Our ref: Mixed Use Development at 17 -24 Loftus Cr, Homebush (SSD-81767963)

27 February 2026

Subject: Request for Information

**RWT & SF & OSD PLAN VIEW**

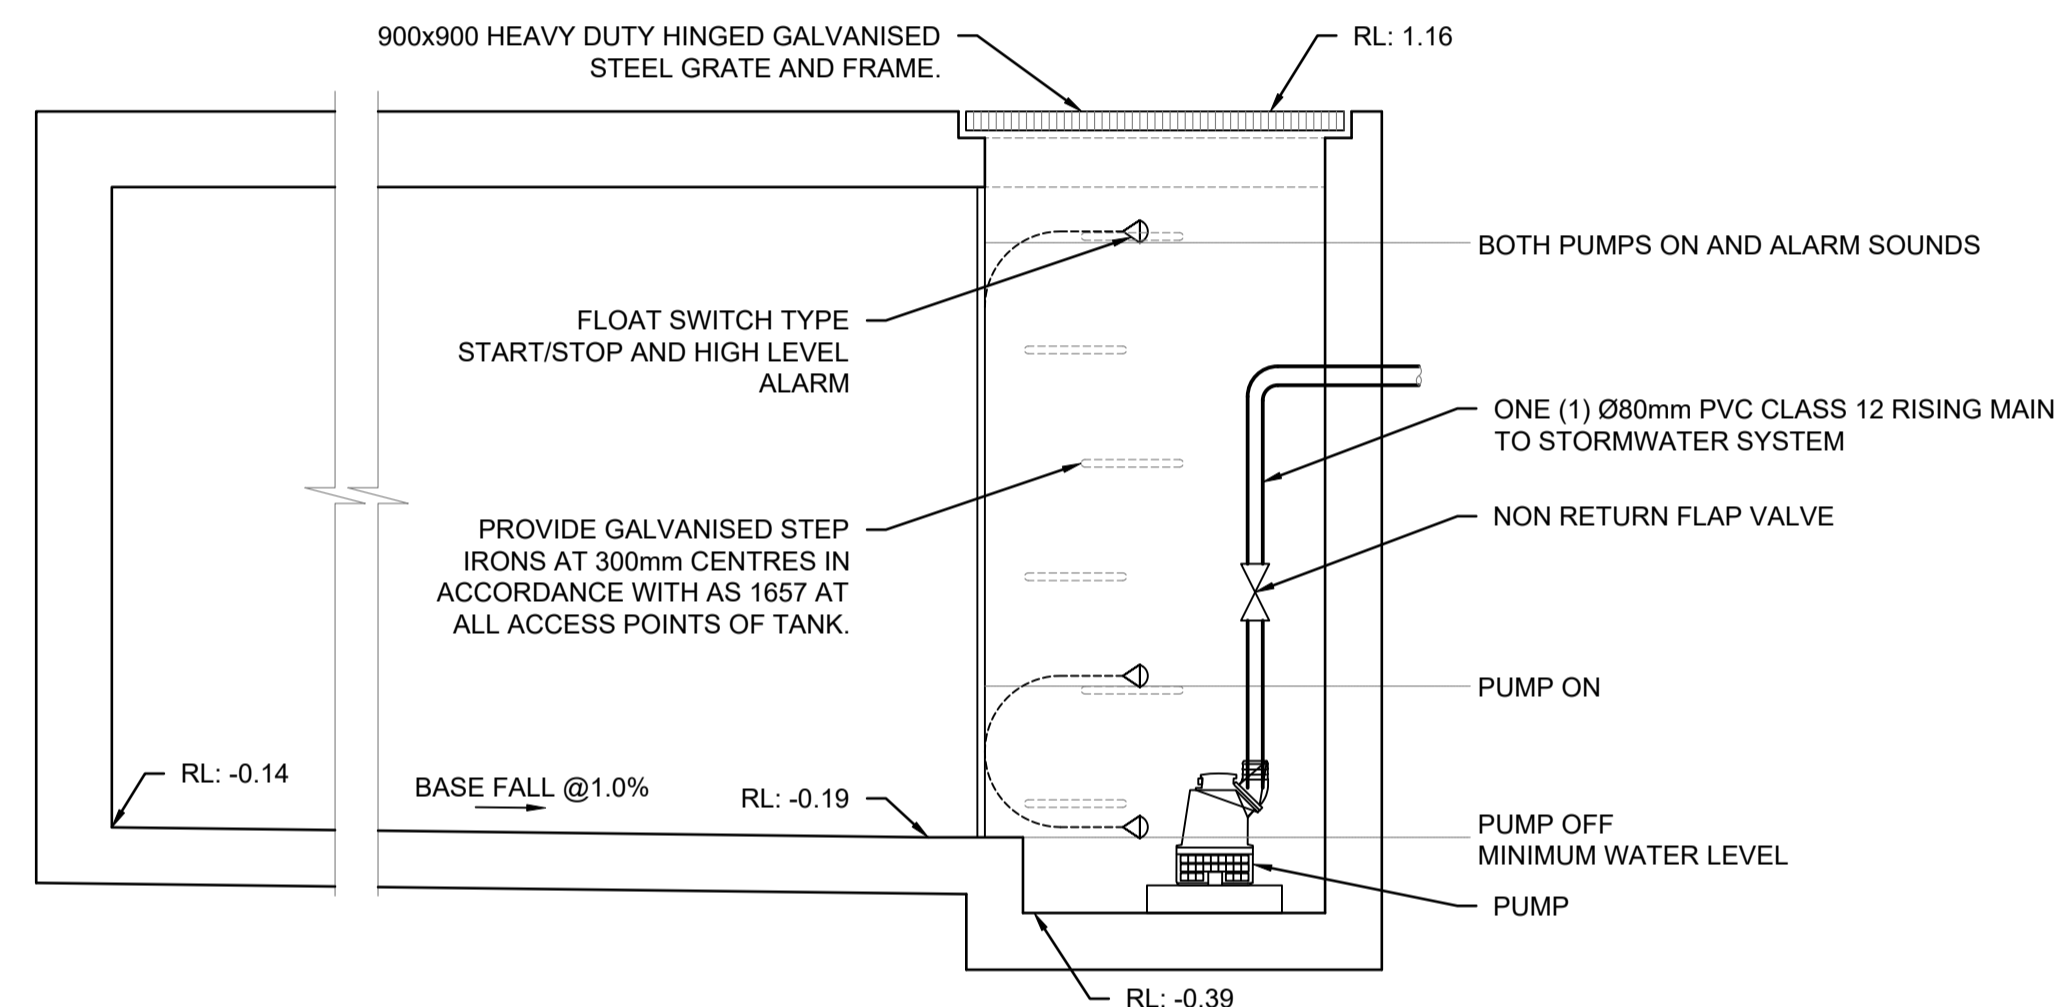
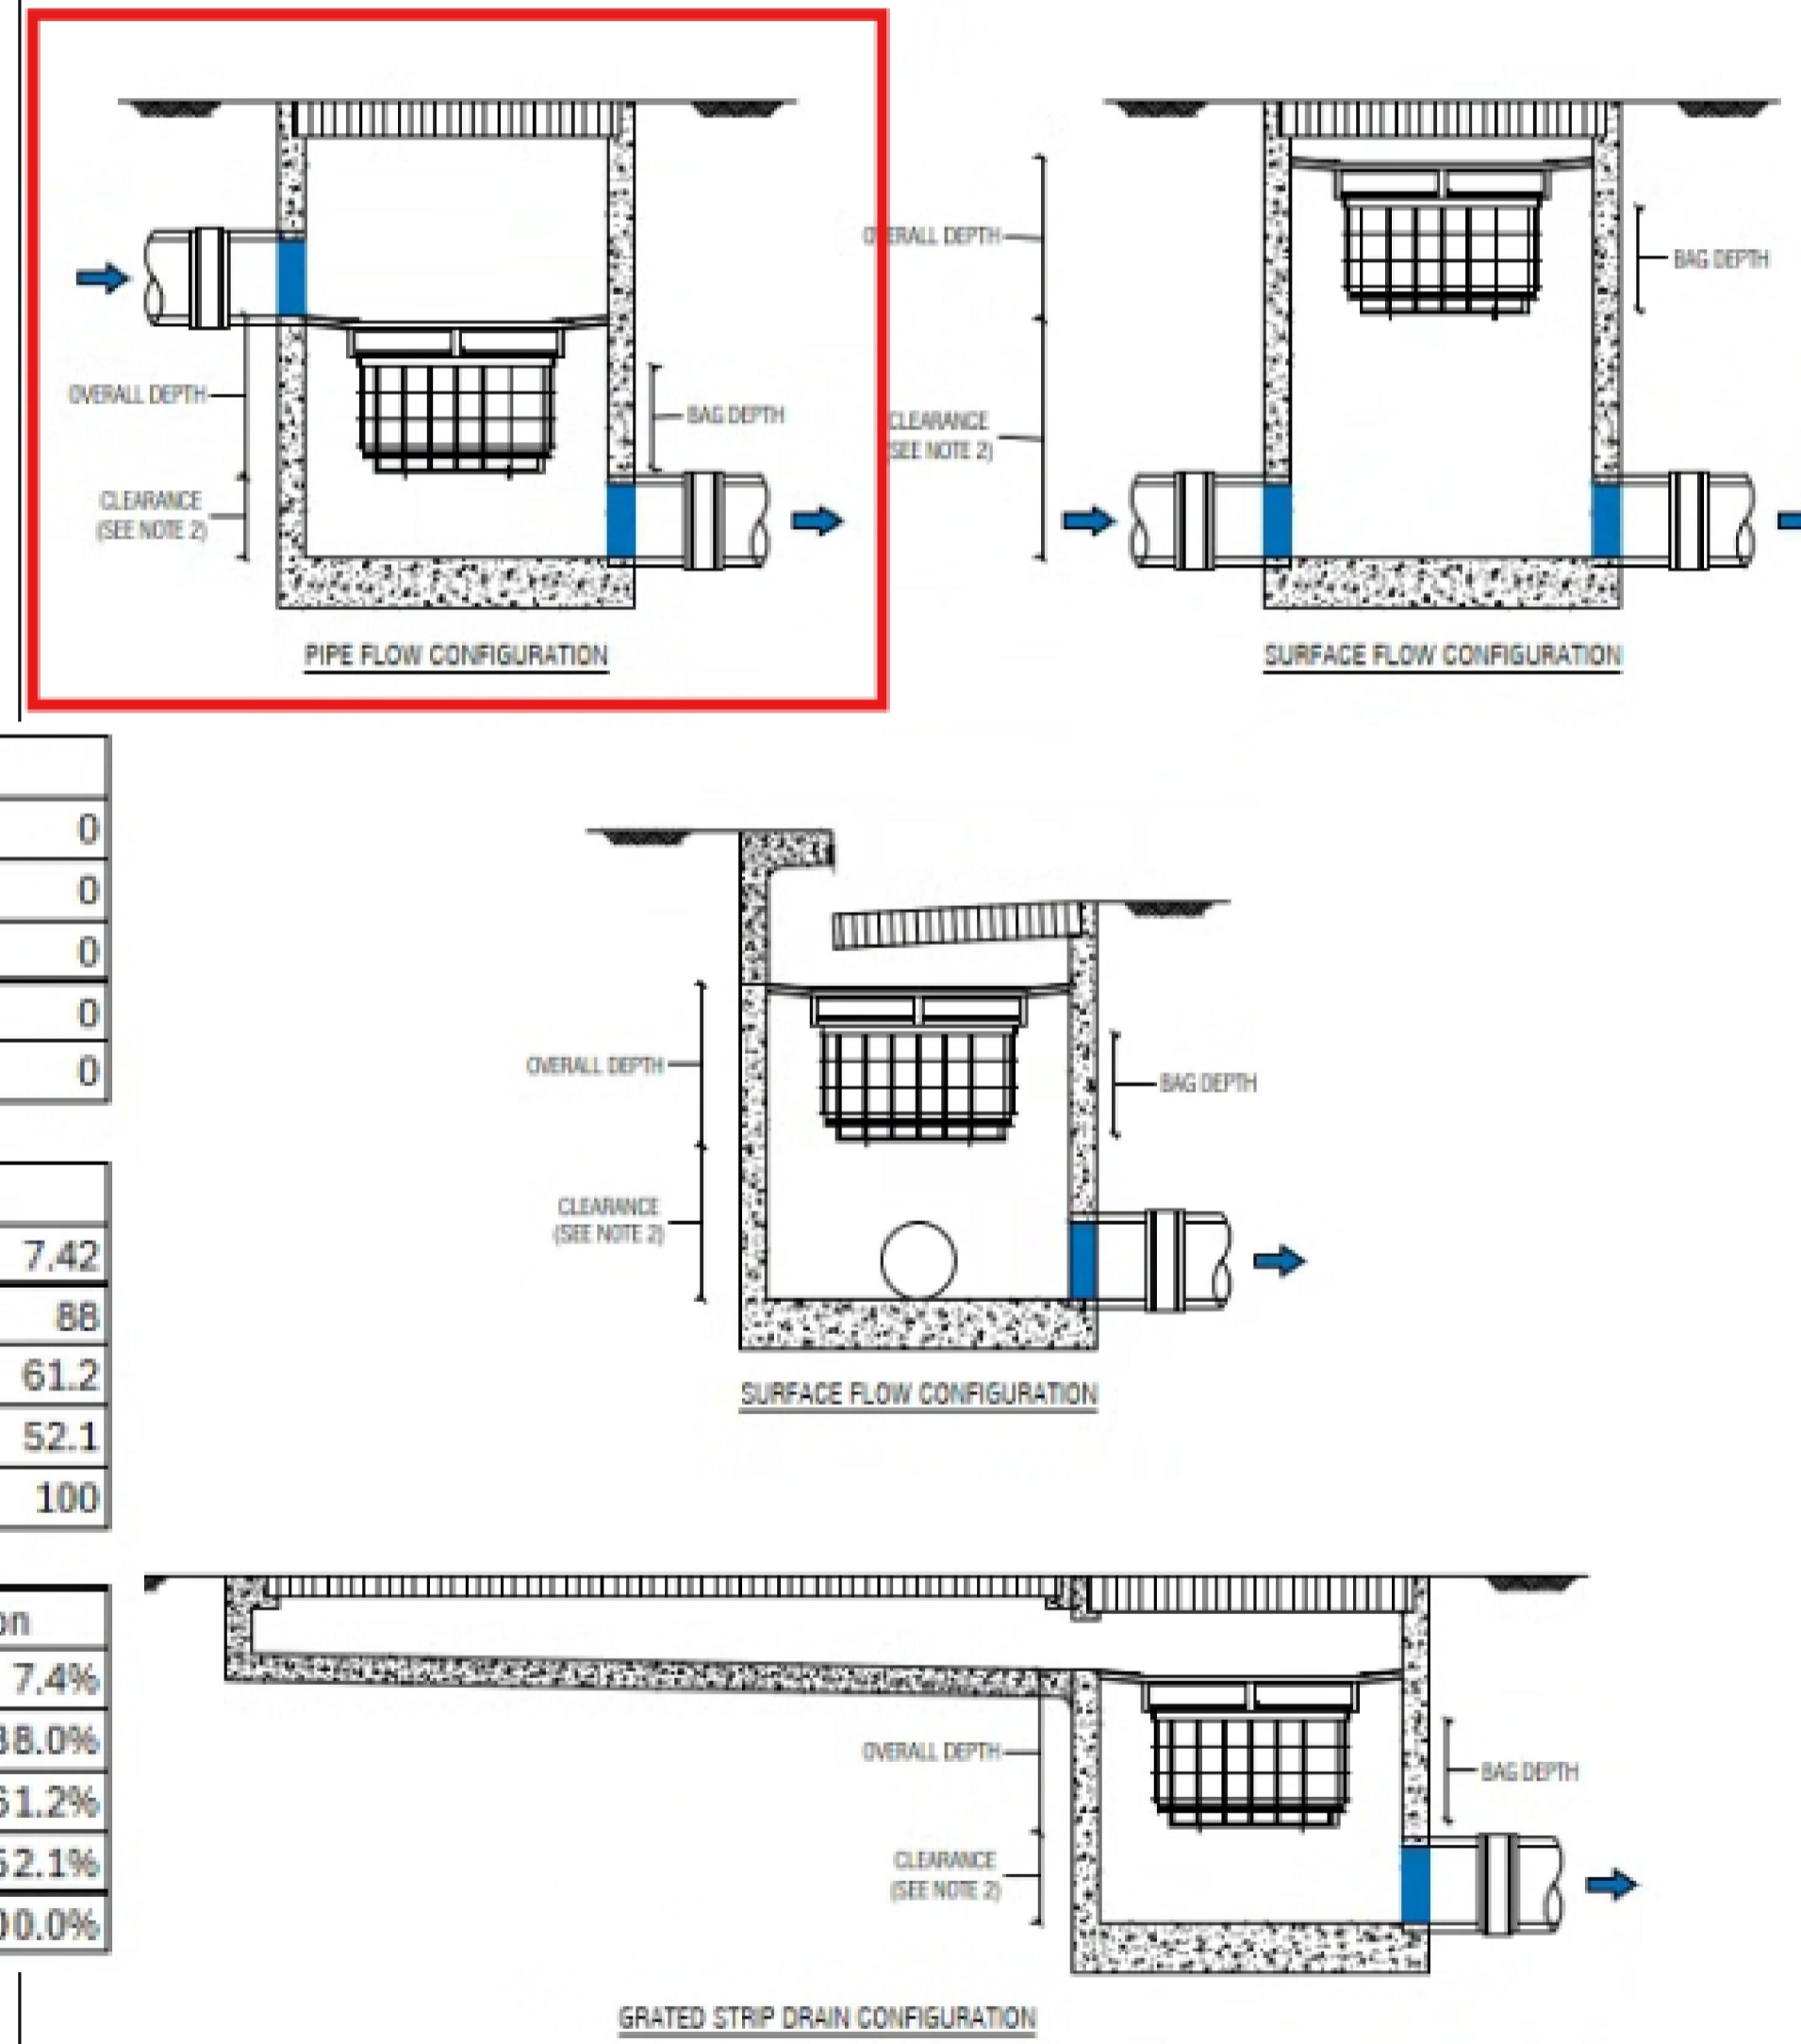
Section Plans demonstrating the location of the proposed OSD system must be provided.
